CITY OF ALBUQUERQUE

Re: La Veta Plaza, 5511 Lomas Blvd. NE,
(J-18/D037)
Approval of Permanent Certificate of Occupancy,
Engineer's Stamp Dated: 10-01-08
Engineer's Certification Date: 4-06-09

Re: La Veta Plaza Grading and Drainage Plan
Engineer's Stamp dated 10-1-08 (J18/D037)

Re: La Veta Plaza Grading and Drainage Plan
Engineer's Stamp dated 5-24-07 (J18/D037)

C-1

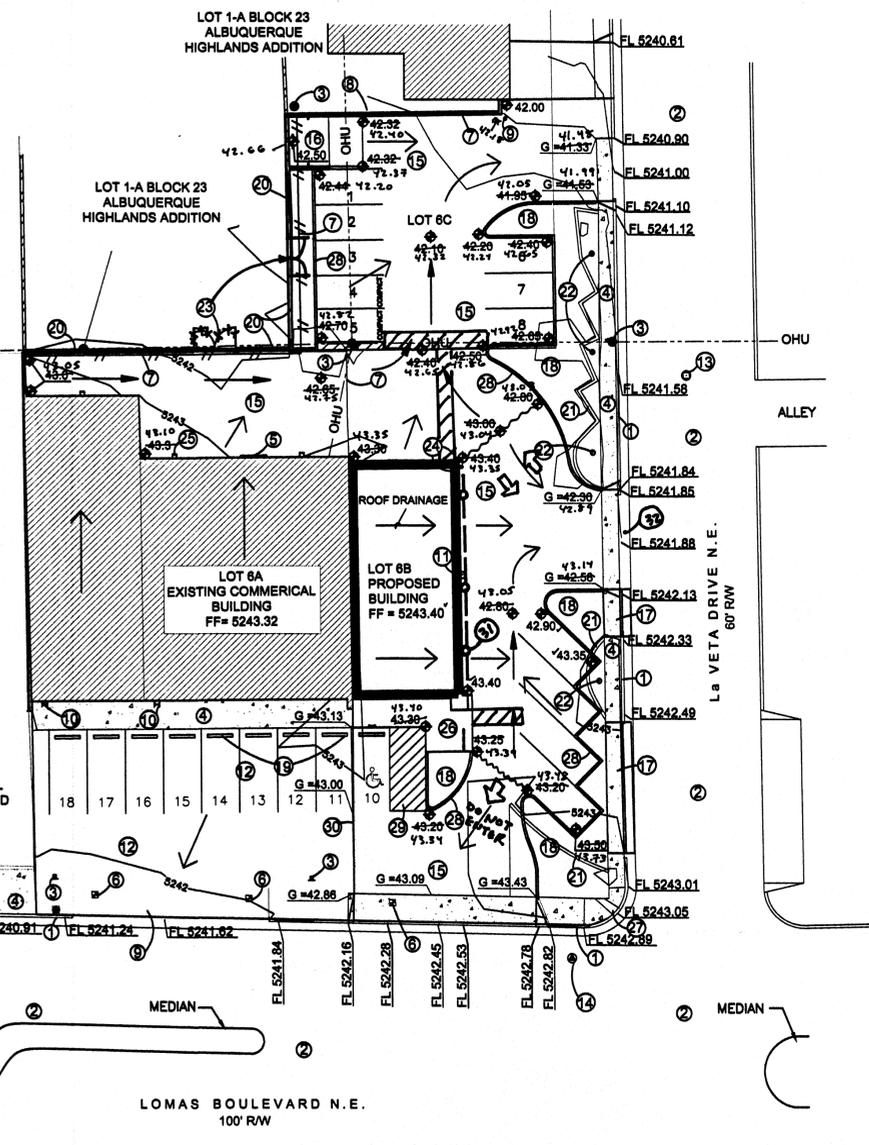
Per our discussion, 10-17-08, the owner is to sign a statement on the plan approving the cross-lot drainage. Since it has been nearly one month since our discussion it was time to close this submittal.

- There has been a change in policy on the trash enclosure drains. Currently, only food preparation businesses require the trash enclosure to drain through a grease trap to the sanitary sewer. Trash enclosures at other business types should not drain to the sanitary sewer.
- Cross-lot drainage easements will be required since lot 6B is draining across Lot 6A and Lot 6C.
